DECISION DELEGATED TO DEVELOPMENT MANAGER

Application No: H16-1165-18 **Applicant:** Mrs Tracey Quinn
Proposal: Proposed extension and alterations
Location: 7 Monks Walk Spalding
Terminal Date: 16th January 2019

CASE OFFICER ASSESSMENT

Drawing Title :
Option 2 Proposals
Alterations & layout proposals

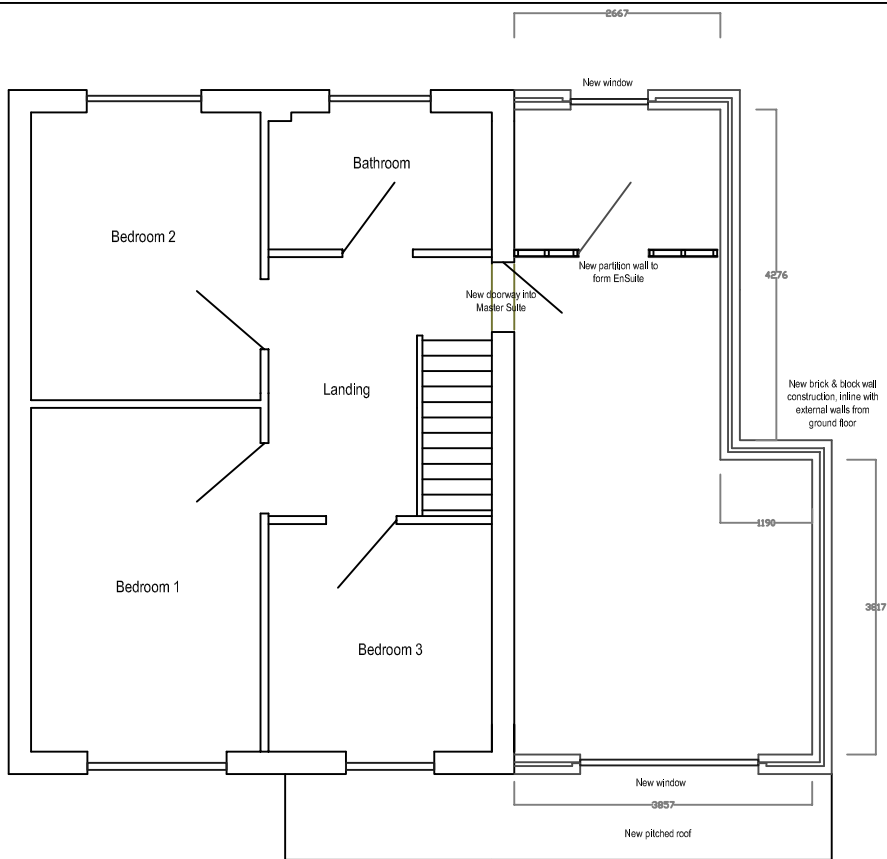
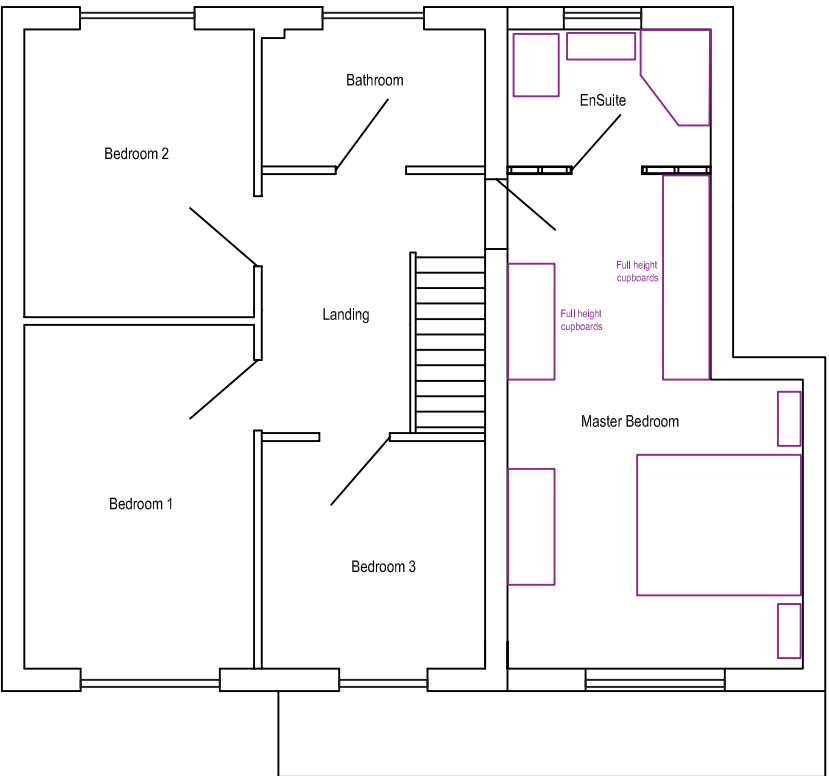
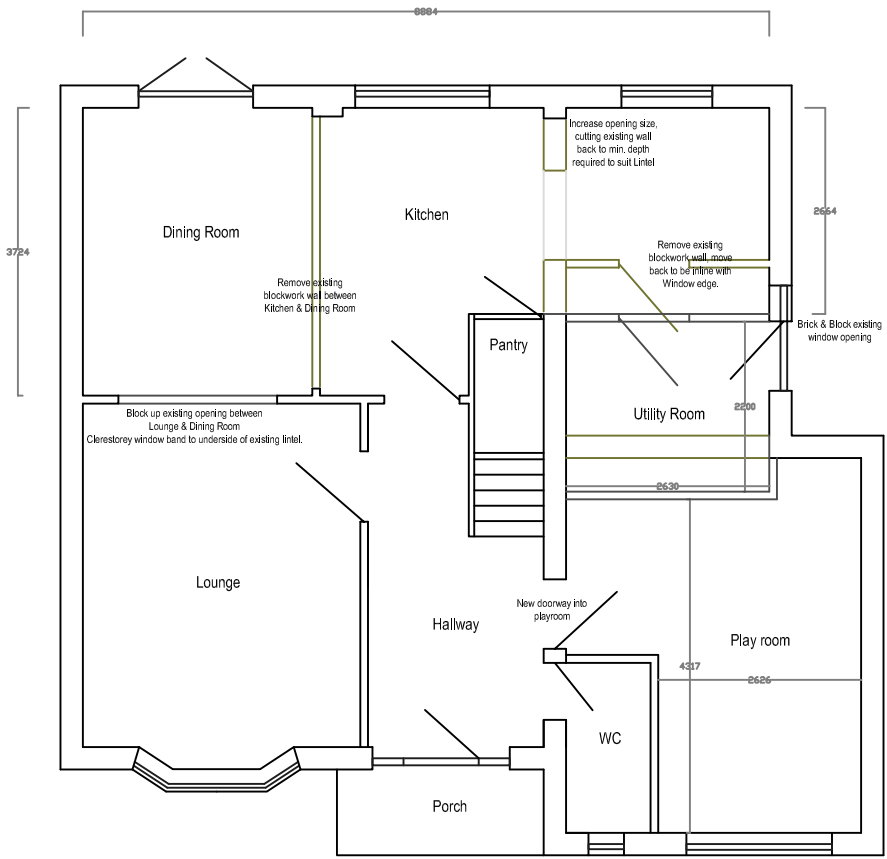
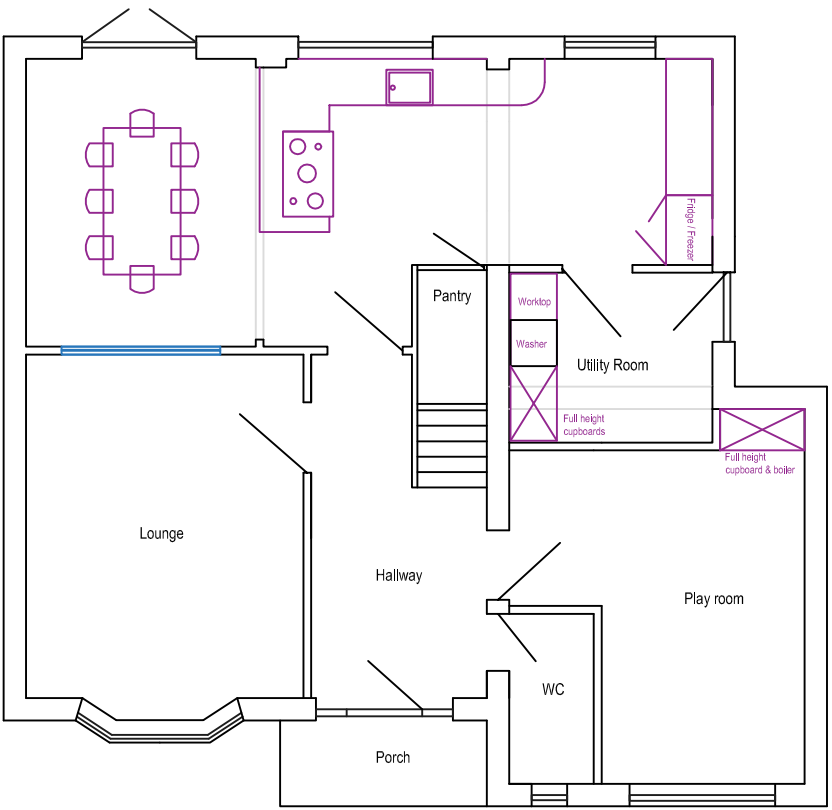
The proposed extension is first floor above the existing garage and utility room. Its dimensions would be as much as those of the house. The development would be therefore subservient to the host property in terms of scale, massing and bulking.

The proposed floor layout reveals that the extension is aimed to enlarge the kitchen and create a play room downstairs and create an ensuite master bedroom upstairs. Alterations such as wall demolition, wall erection and additional openings are acceptable as extended. The layout is considered to be in accordance with the increasing needs of the occupiers.

Drawing Title :
Option 2 Proposals
Proposed Elevations

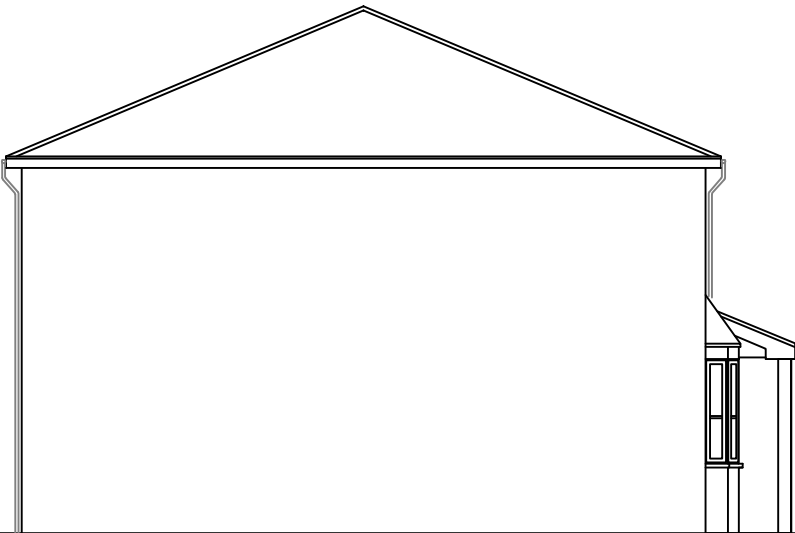
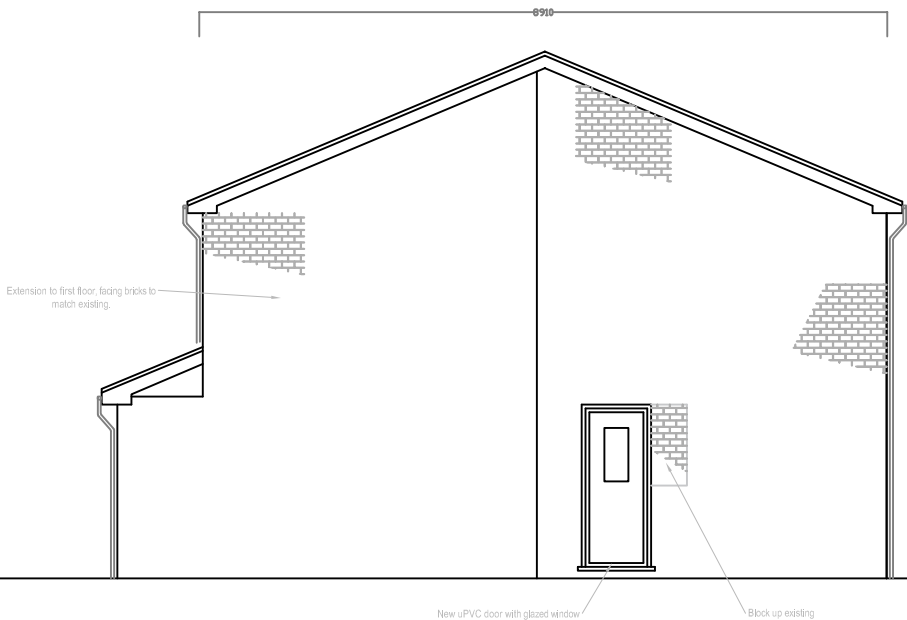
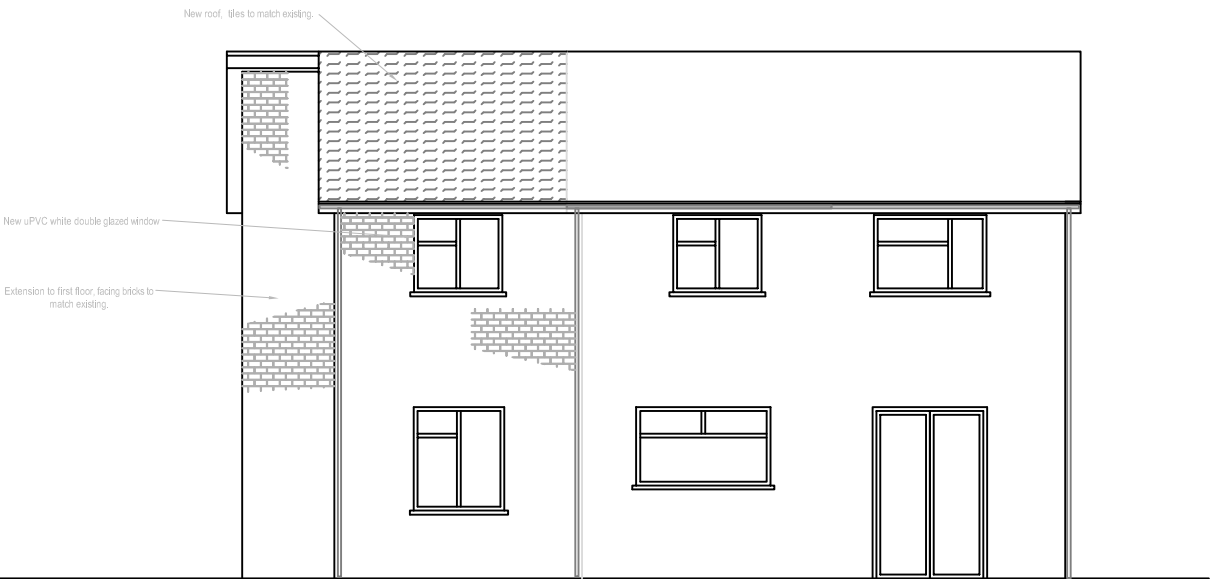
With regards to external design, the roof on top of the extension would represent an enlargement of the existing gable roof of the dwelling. An additional gable roofed window would be opened upstairs on the front elevation replicating the existing one at the opposite end. The roof canopy on top of the porch would be enlarged filling the full width of the extension. Both architectural features would deliver a more integrated form of development to the host property. Roof tiles, facing brickwork and UPVC in new fenestration would match as close as possible those existing in the dwelling. For these reasons, the resulting design would not have any harmful impact upon the visual amenity.

There is a nearly 2 metre high timber close board fence along the site boundary with adjacent property No. 5. Whilst the first half of the boundary with No. 9 is poorly screened with 1 metre high timber close board fence, mature tall hedgerow is located along the second half. The position of additional fenestration would not overlook to opposing elevations. Given the position within the sunpath, the development would not cause any overshadowing, especially to No. 5 which is the closest building. Having regard to this as well as the existing boundary treatment, the development would not be overbearing and overall the residential amenity would not result undermined.
